30th March 2021

RE: Planning Application 21/00922/OUT
Land West of Foxden Way Great Bourton

ATTENUATION POND DETAILS
 DESIGN BASED ON IMPERMEABLE AREA OF 0.39HA INCLUDING A 10% ALLOWANCE FOR URBAN CREEP.

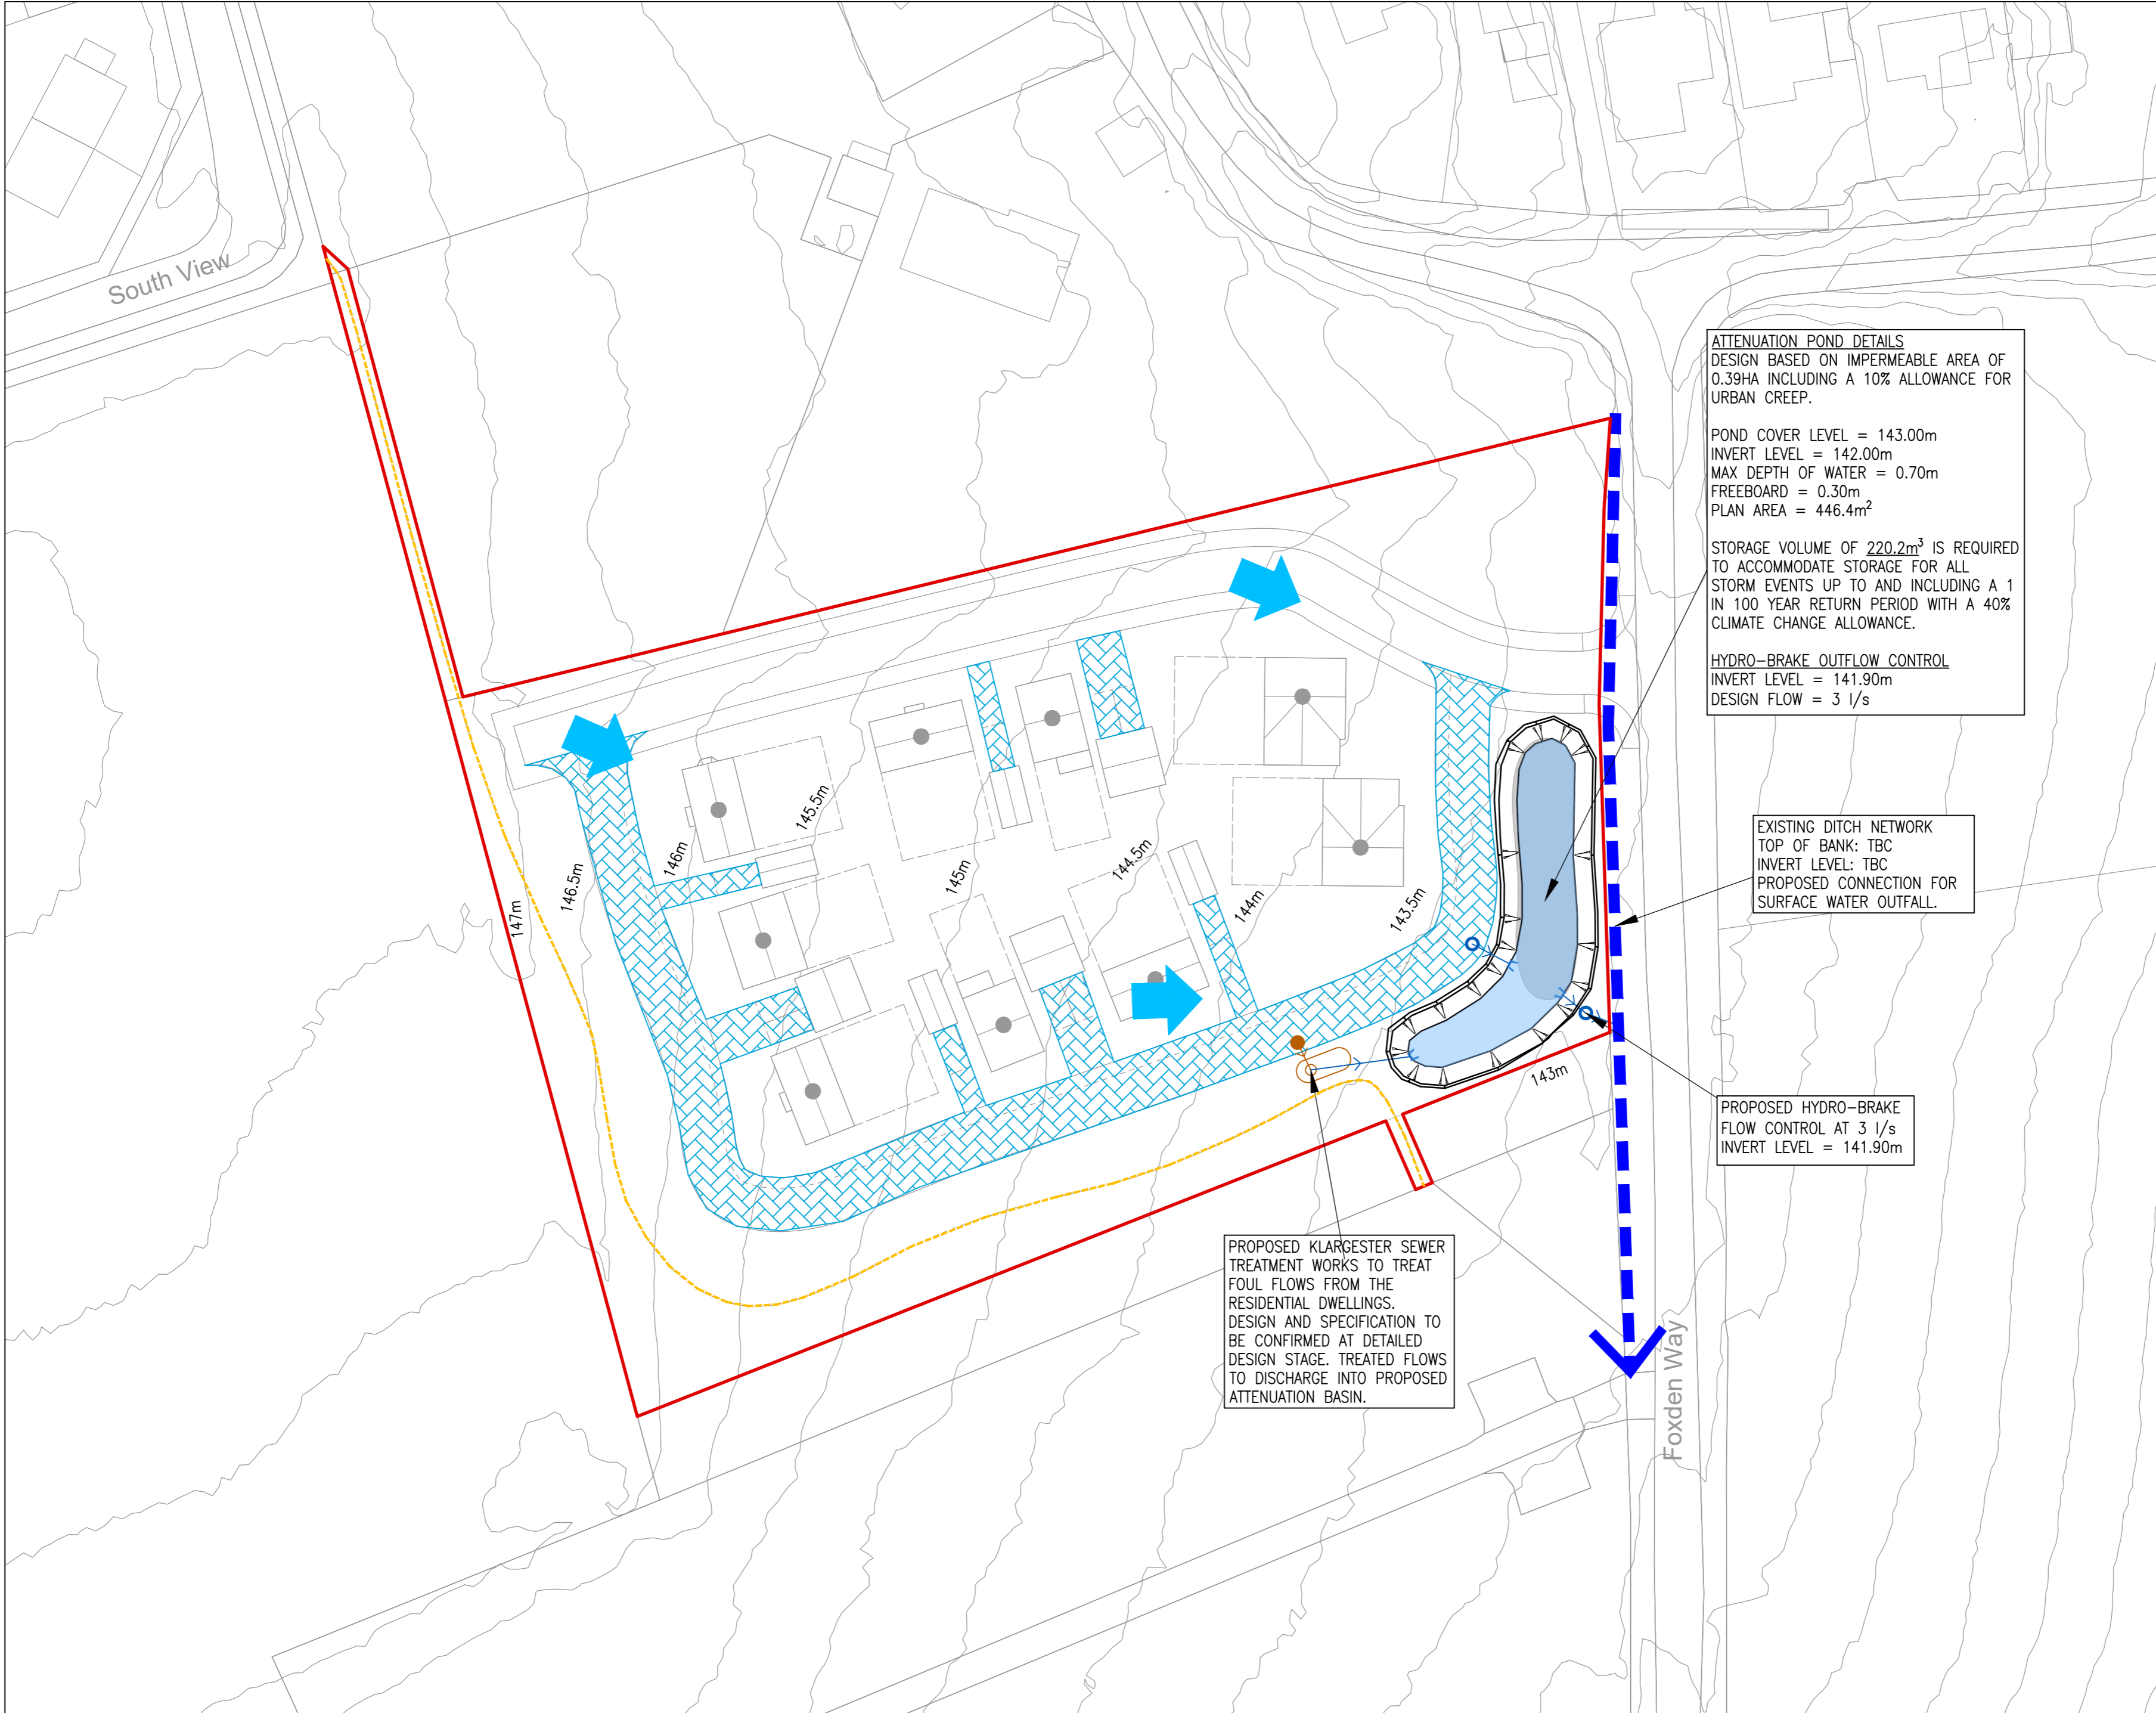
I note that the Agent states the site is impermeable as it has a clay substrata and this is correct. I note that a permeable road is highlighted marked Blue on part of the plan but no mention is made of the access road marked Brown on my plan. When this substrata is clay even a permeable road will have to be piped to the ditch. Much of the site will naturally drain to Crow Lane causing even more flooding.

There is no easy access to the main sewer and there are now strict conditions which in many cases do not allow on site sewer treatment into water courses. This site is not permeable and a soakaway system is not possible especially when it is to serve a small estate. There would need to be significant ditch re profiling to where flows would have to go under the road and from there more ditch work across the top of the Cemetery to Mill Lane. This would all need regular maintenance. We already have flooding at the bottom of Mill Lane where ditch flows are restricted by the Railway culvert that already causes flooding to both mine and my neighbour's land. There is no doubt that these flows would have an unpleasant aroma and with the added flooding risk this application should be refused.
